V3_zone Map comment.pdf Markup Summary 3-8-2023

Subject: Callout
Page Label: [1] Rezone Exhibit
Author: dsdparsons
Date: 3/8/2023 2:34:47 PM
Status:
Color: ■
Layer:
Space:

REZONE EXHIBIT

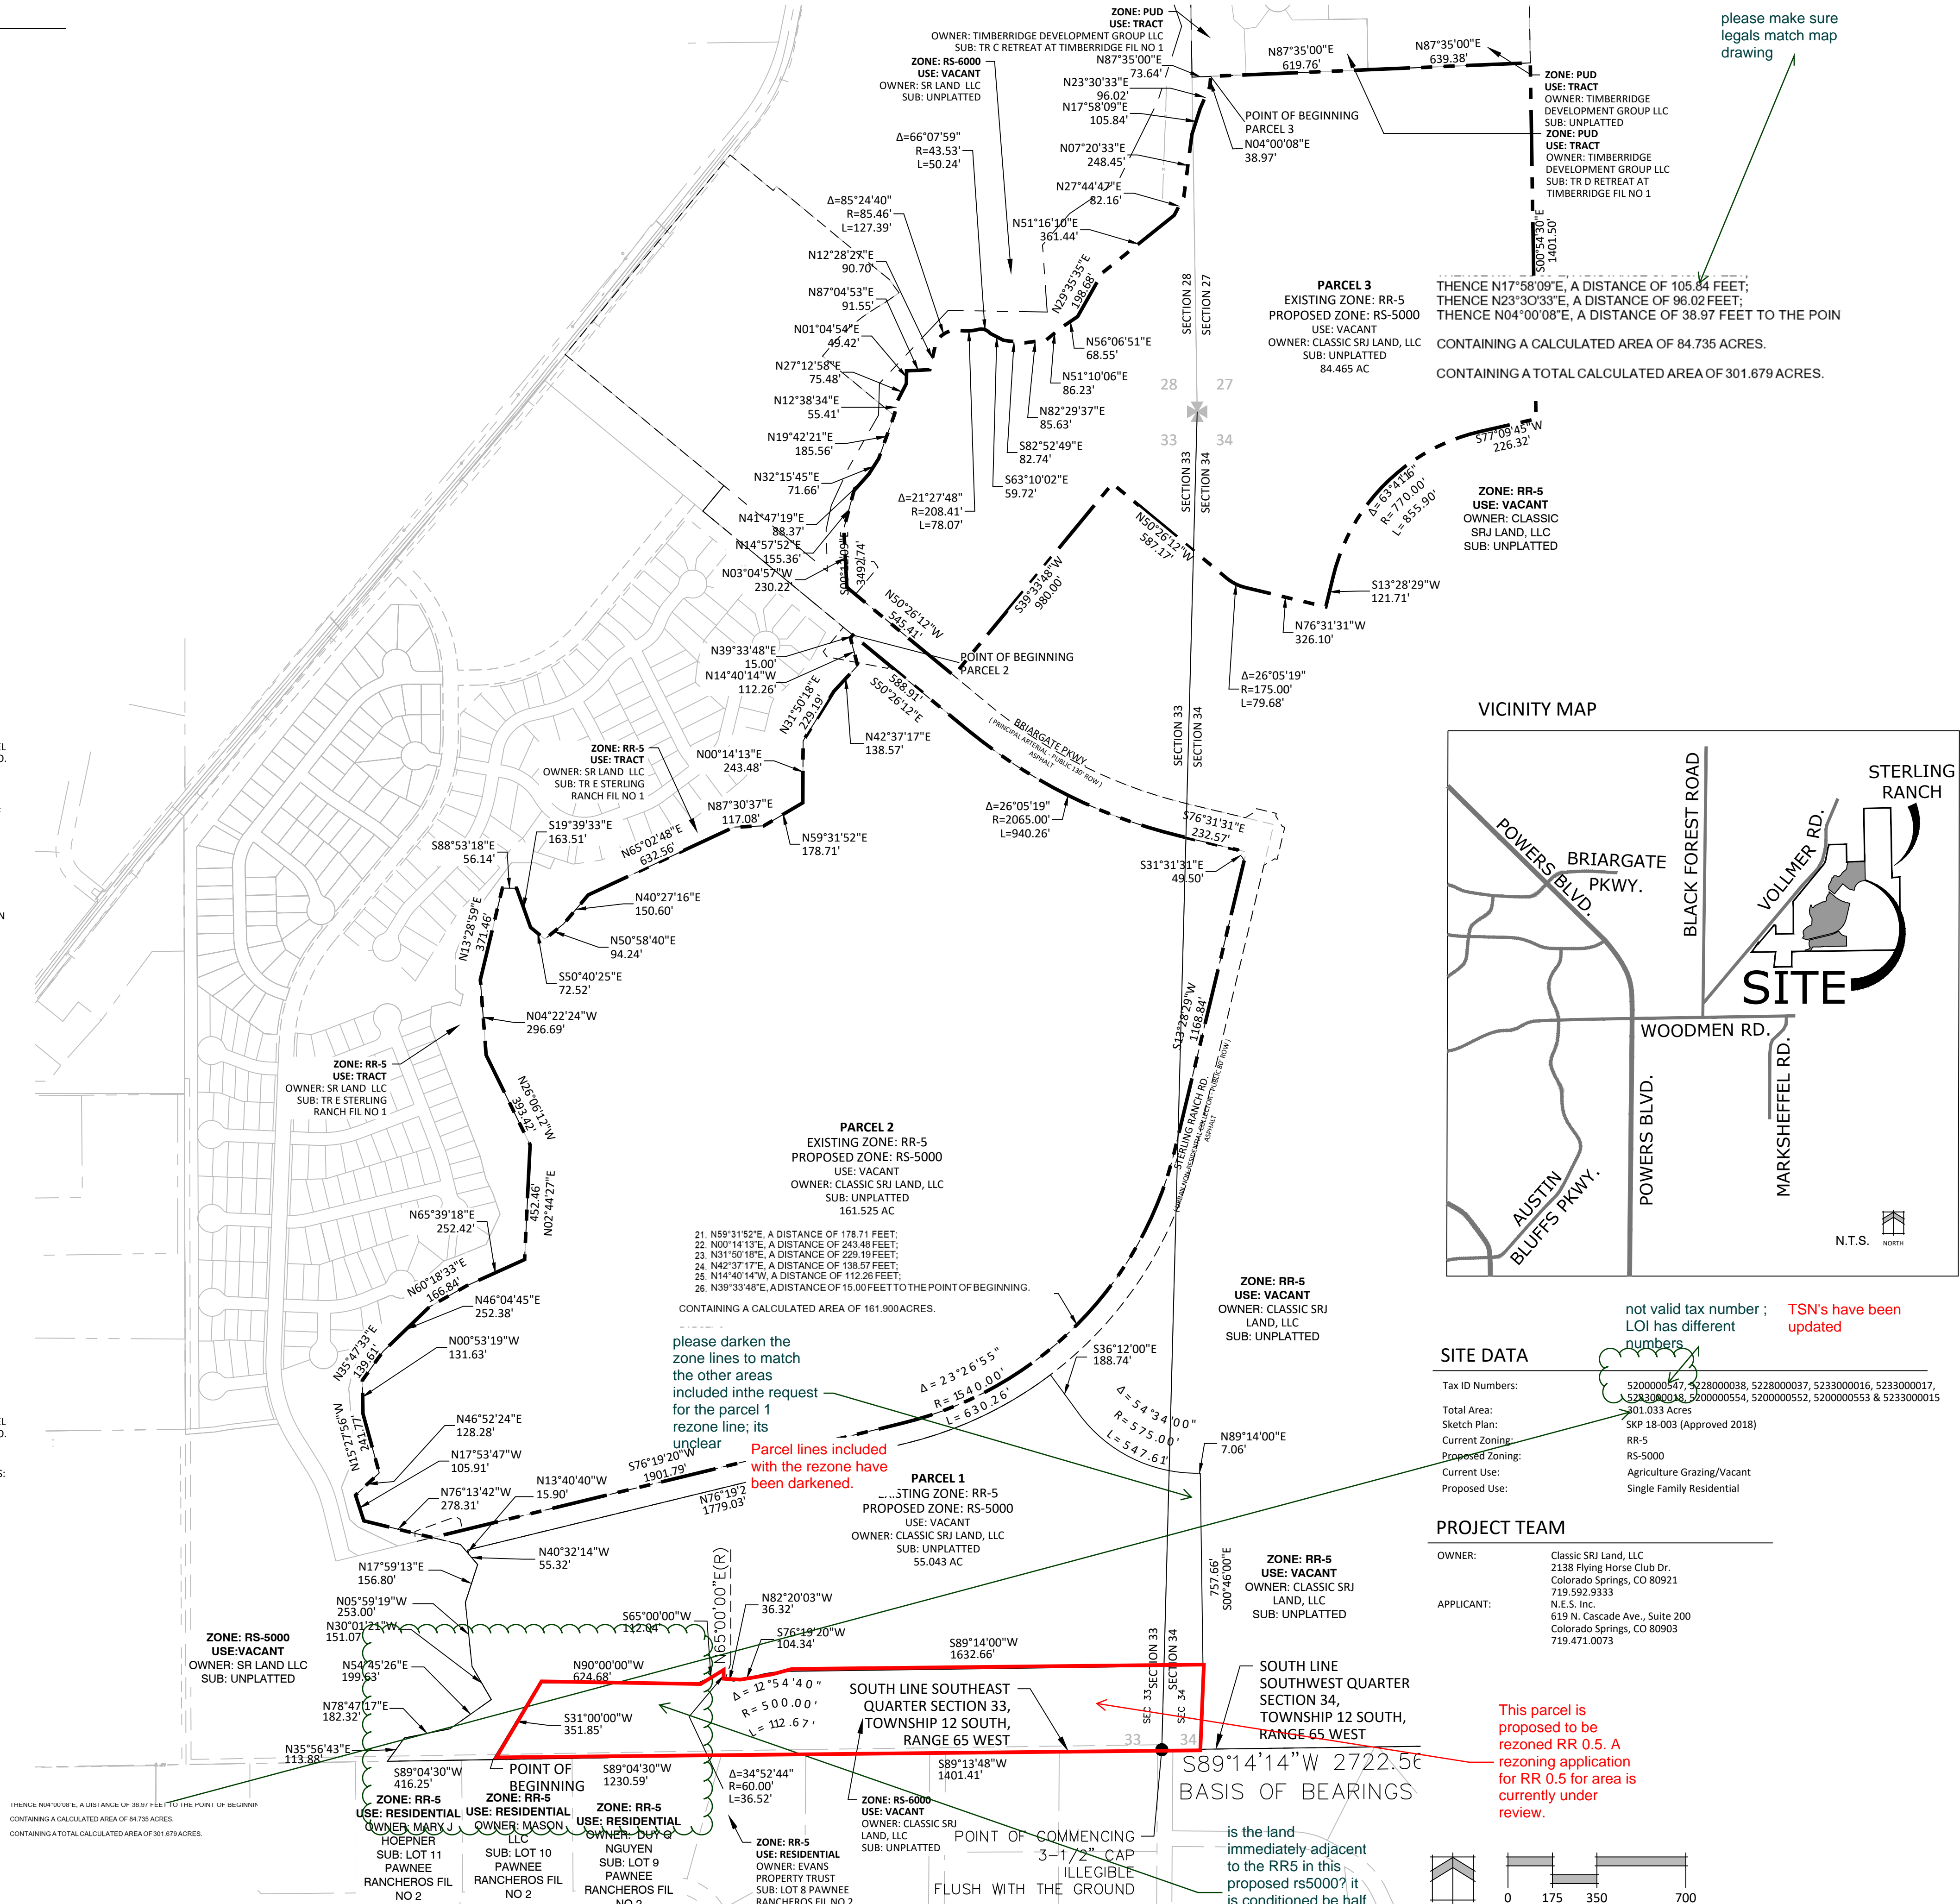
this is not correct; this is proposed to be rural (RR0.5) not urban. Existing RR5 ; proposed RR 0.5. (Not included with this rezone request)

please make it clear this is not included
